Our ref: DOC20/825597

Senders ref: SSD 9483

Response to Submissions – Chatswood Education Precinct, 5 and 24 Centennial Avenue, Chatswood (SSD9483)

EES have reviewed the RtS table prepared by DFP planning consultants dated October 2020 and makes the following comments.

Figure 2: Location Map

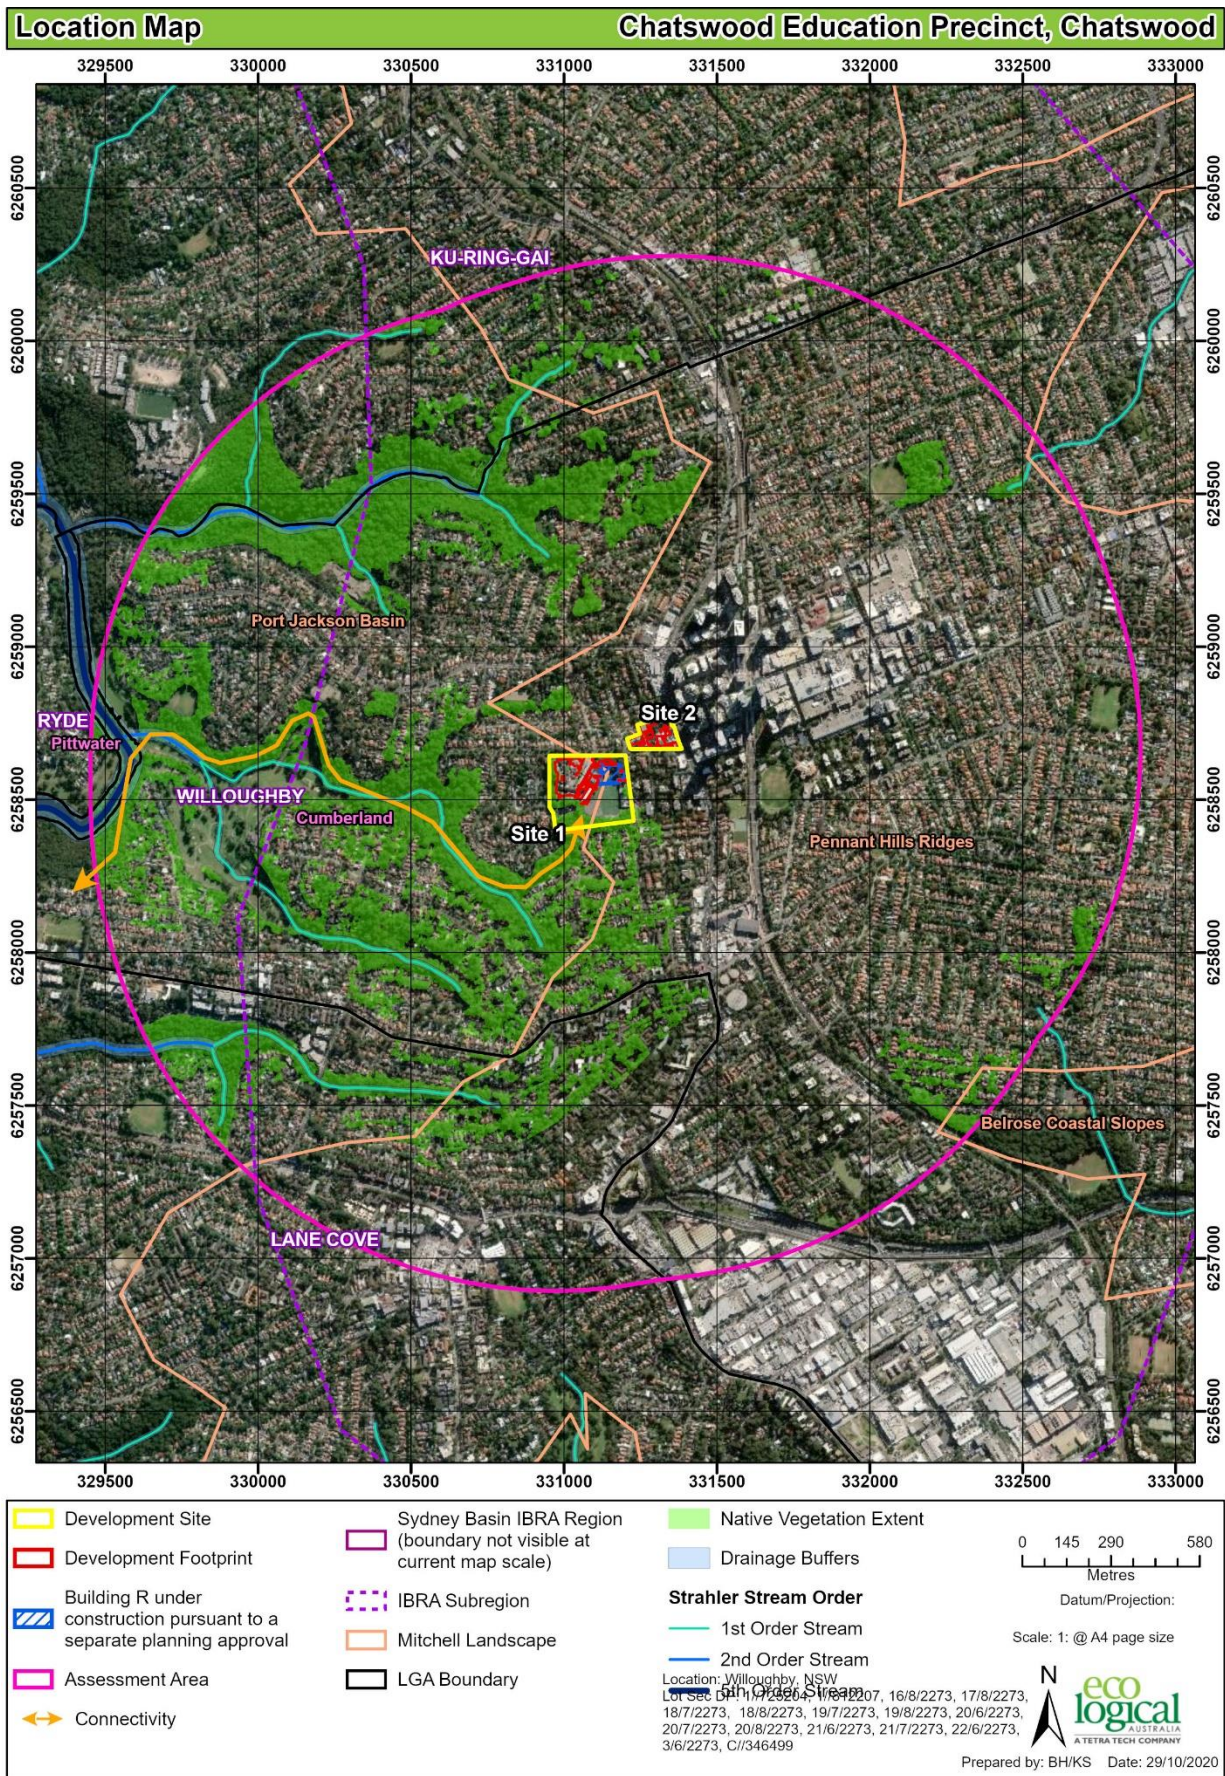
Based on previous comments by EES the landscape features in the calculator and in Figure 2 of the BDAR have been updated. However, Figure 2 now has a thick light blue line that isn't identified in legend.

Figure 4: Vegetation zones and plot locations

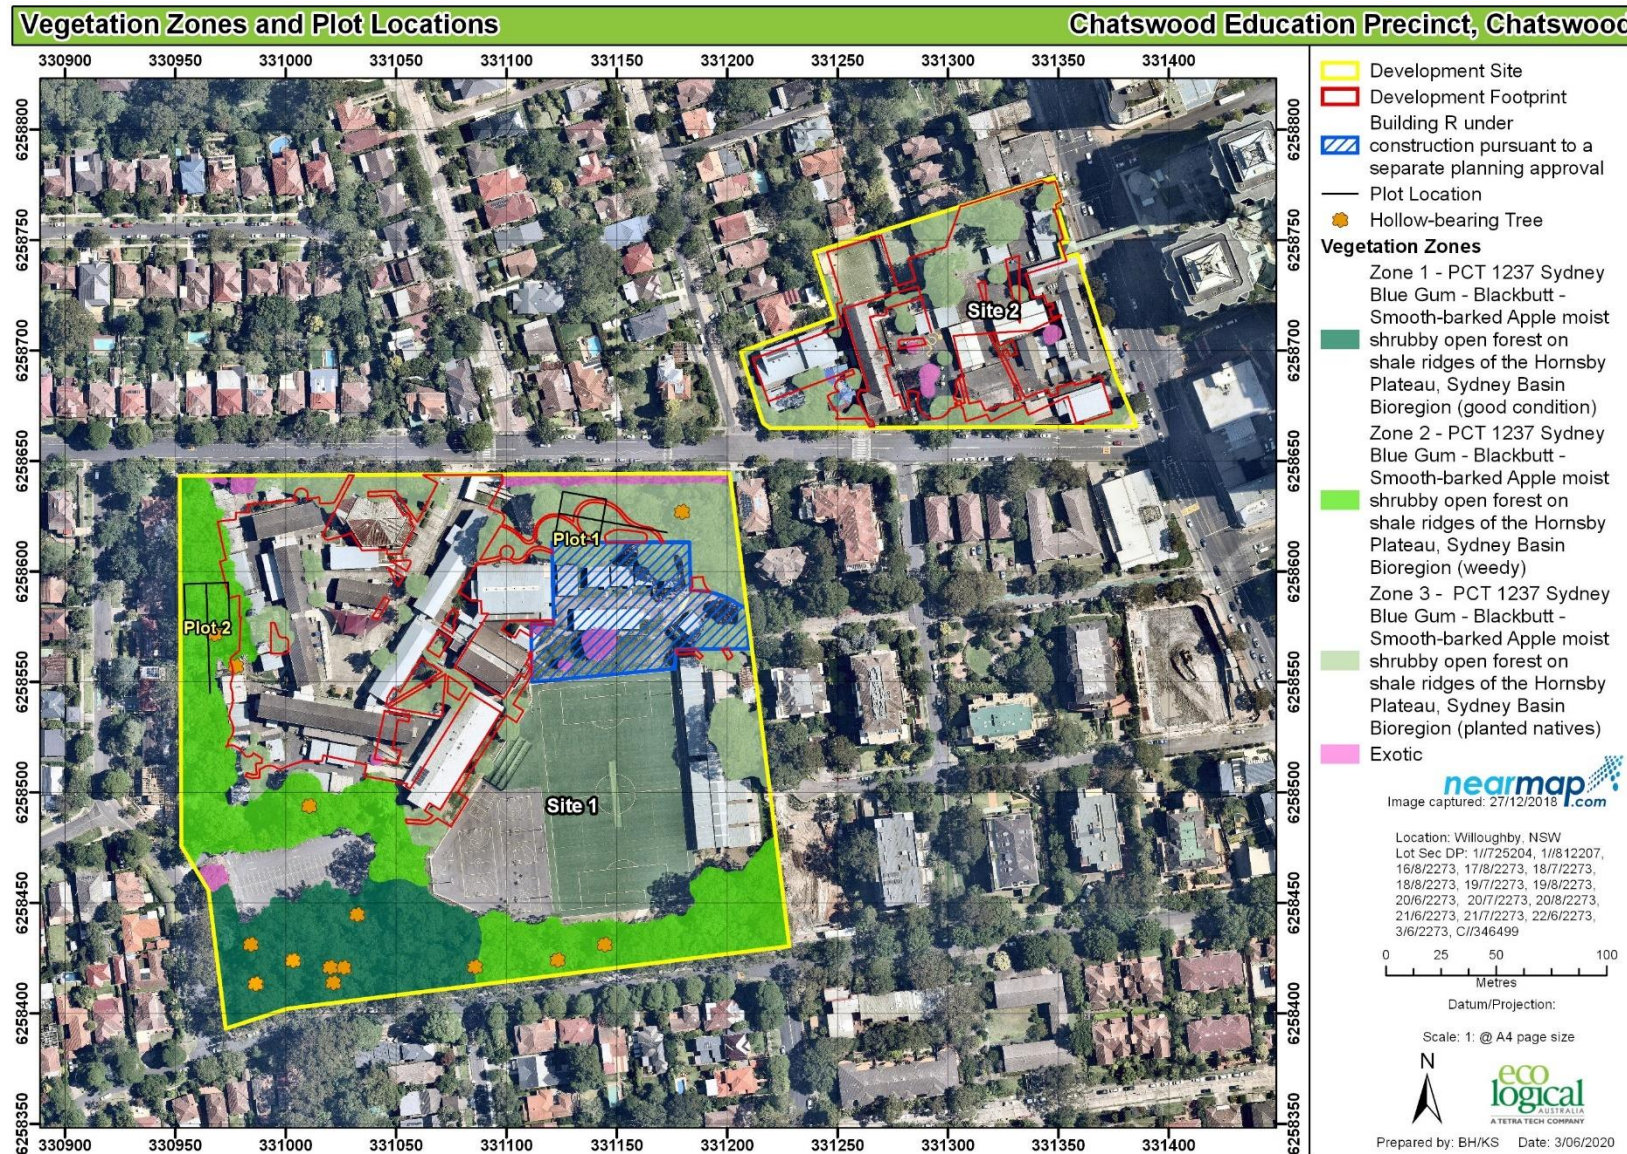
EES questioned the 53 metres of fallen logs greater than 10cm in diameter recorded for plot 2 (VZ 2) as it seems extraordinarily high, especially for a patch of vegetation immediately adjacent to school buildings. EES recommended that this be confirmed. There is no response recorded in the Table.
